DEVELOPMENT REVIEW BOARD
SUPPLEMENTAL SUBMITTAL

PROJECT NO. PR-2019-003461
Application No. SI-2020-00704

SUBMITTAL DESCRIPTION: Plan Updates and response to comments

Project Name: Mesa View United Methodist Church/SARANAM

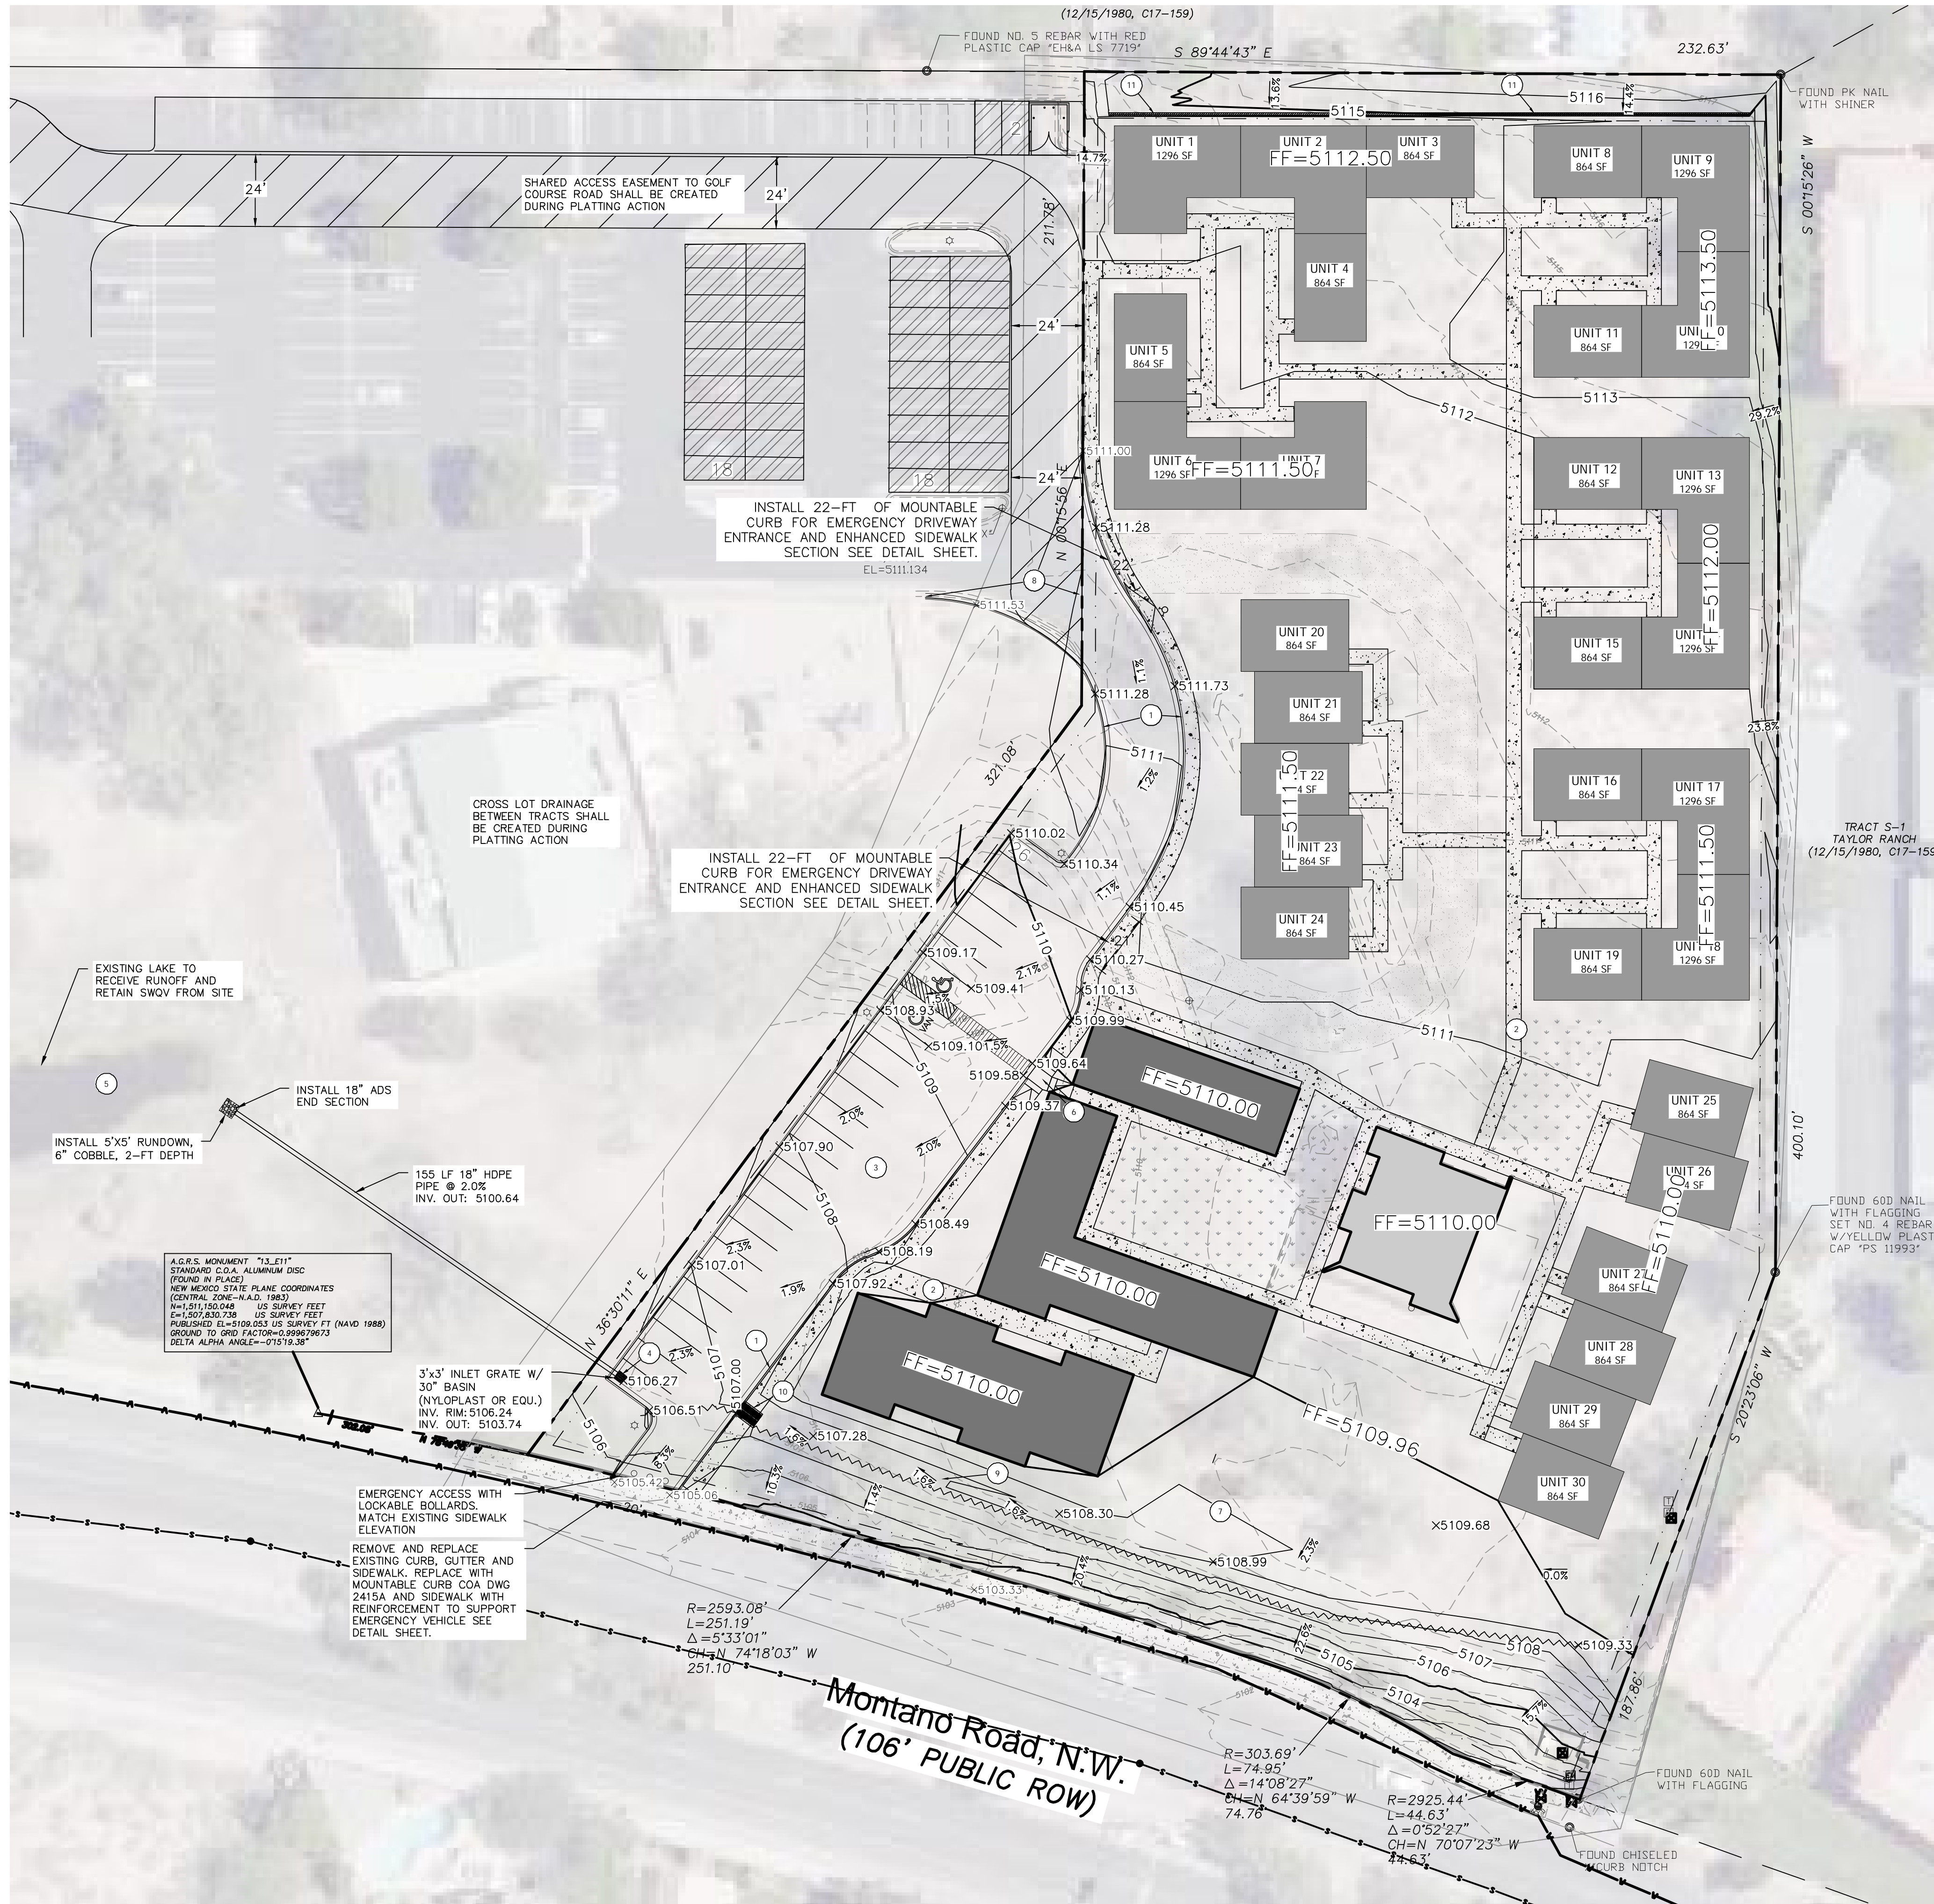
2. The road that Montano Road intersects with is Taylor Ranch Road. Provide correct label on the site plan.

Response: Label on site plan updated.

BOLLARD SPECIFICATION

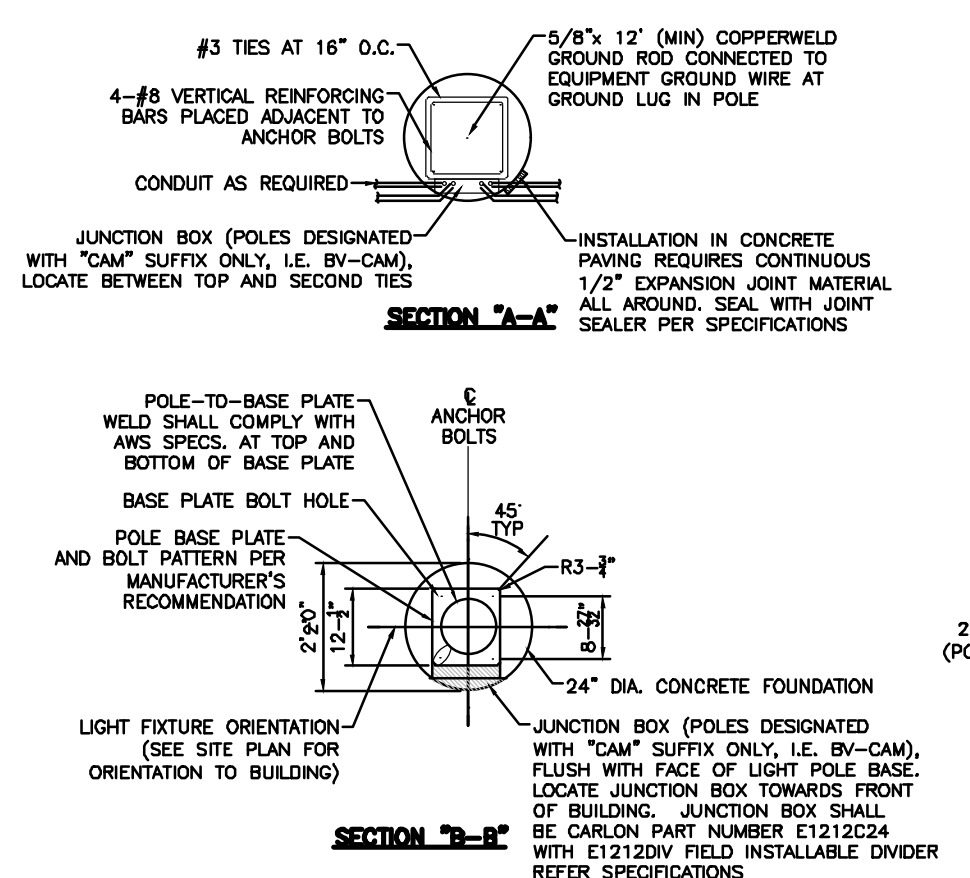
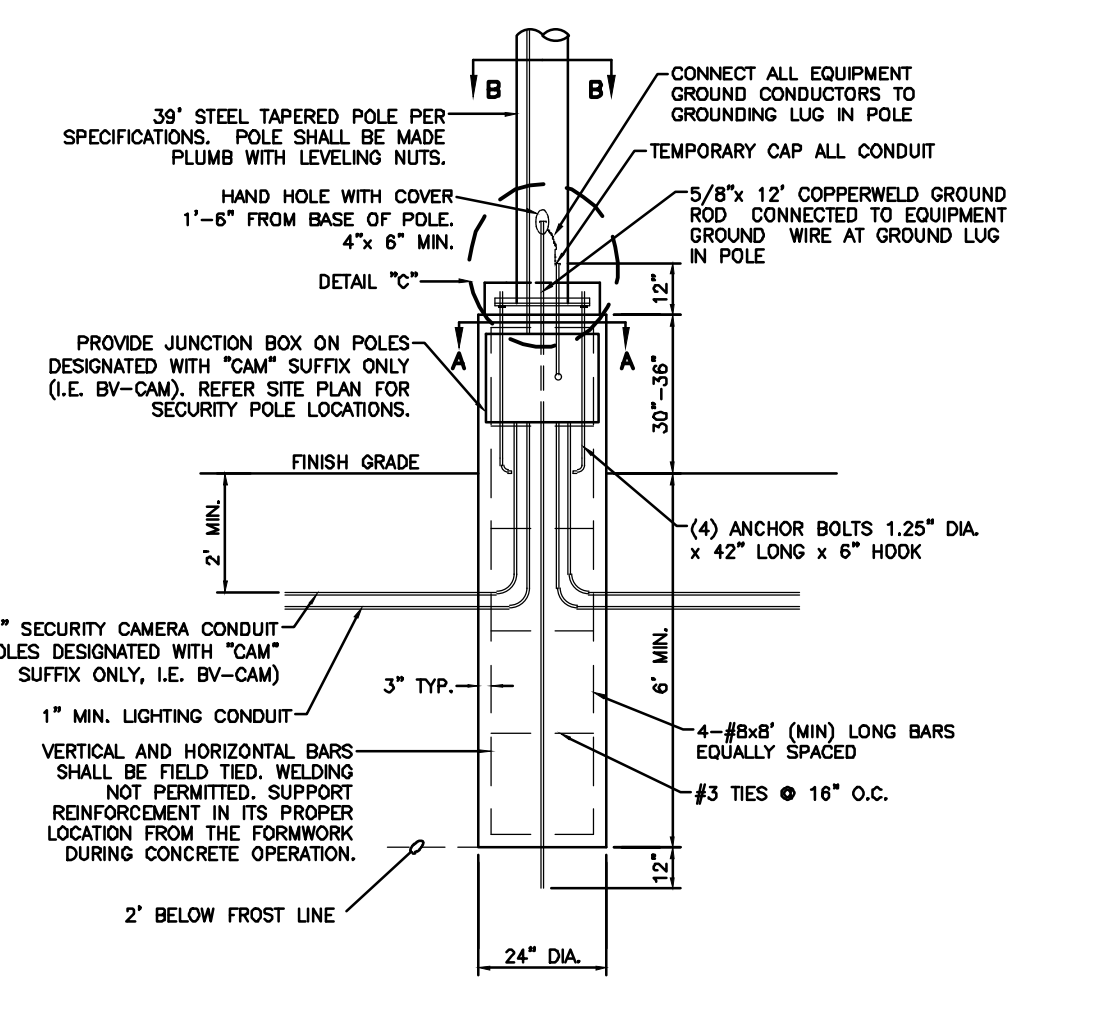
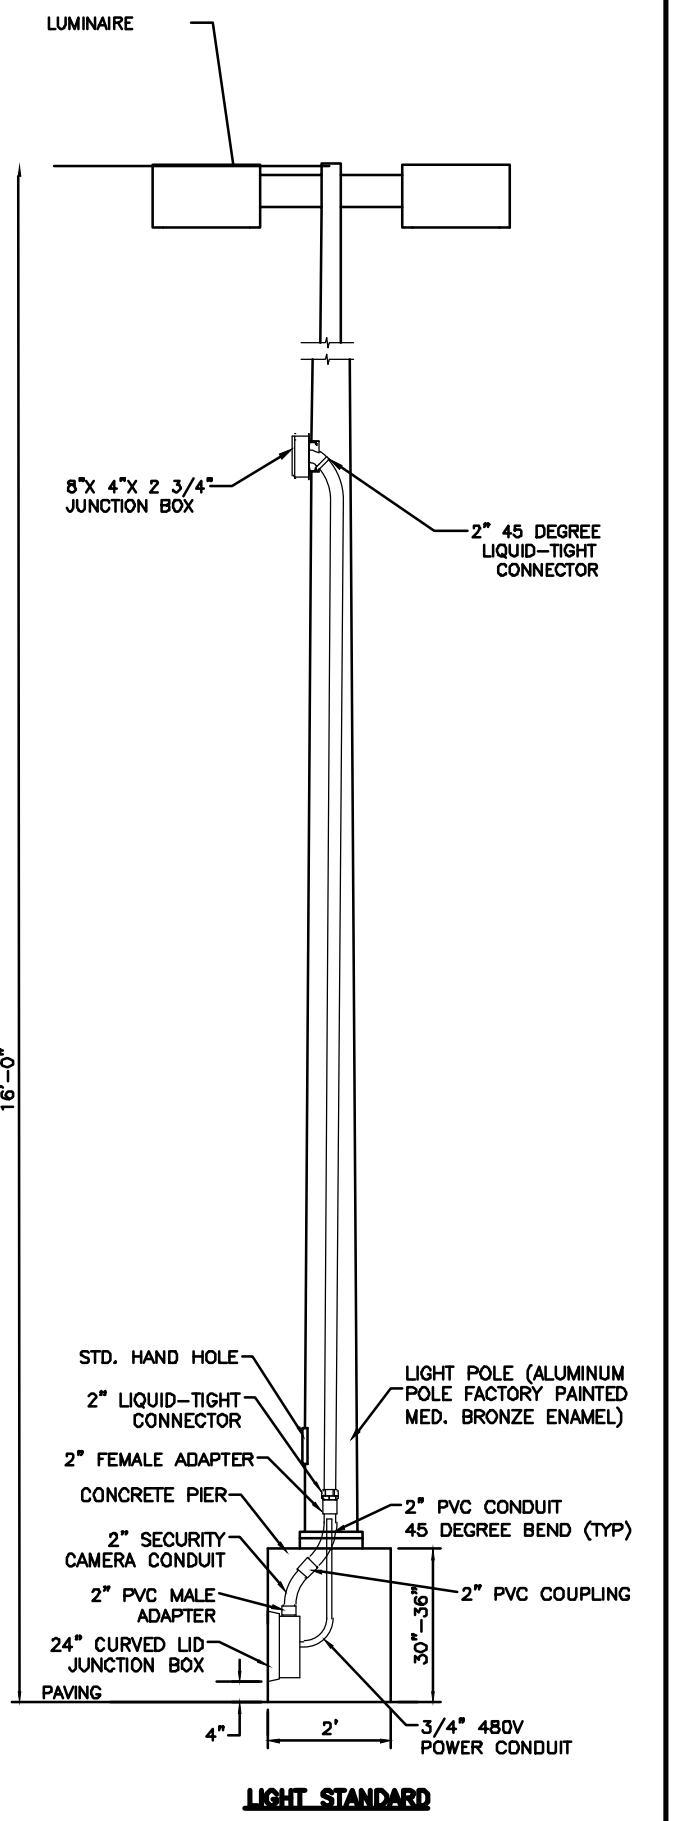
3. What is the foundation for the bollards?

Response: Concrete, added callout detail to sheet C5.
